Please ask for: Ms Iqraa Malik
Email: iqraa.malik@terraquest.co.uk
Telephone: 0121 234 1390
Our Ref: WA/111/21/HH
Your Ref:
Date: 19th November 2021

Application for Planning Permission for Works or Extension to a Dwelling

Development: Erection of two storey front and rear extension with first floor rear balcony following demolition of existing rear conservatory.
Location: Highdown West Walberton Lane Walberton BN18 0QS

BLOCK PLAN
SCALE 1:500

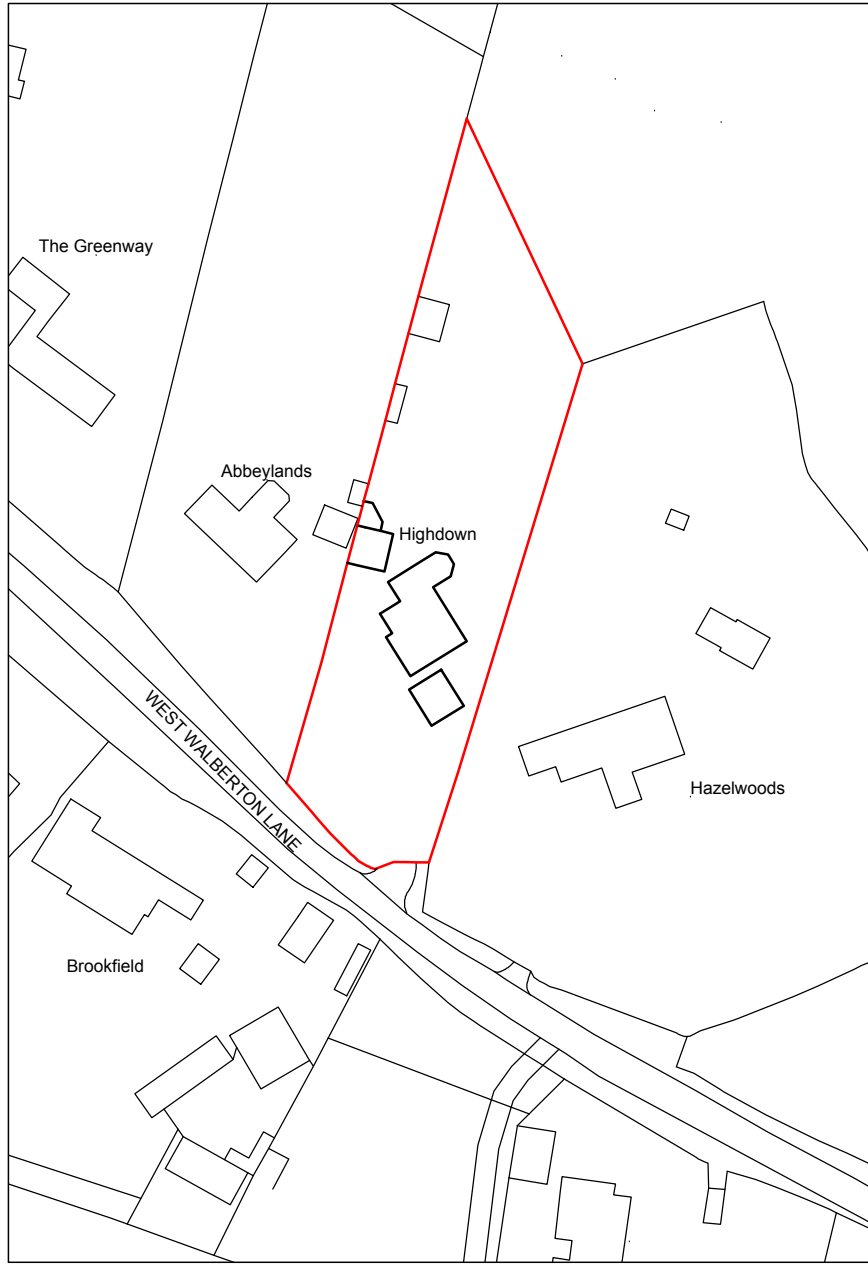
Block Plan

You are required to have dimensions from the proposed extension(s) to all site boundaries. Please amend.
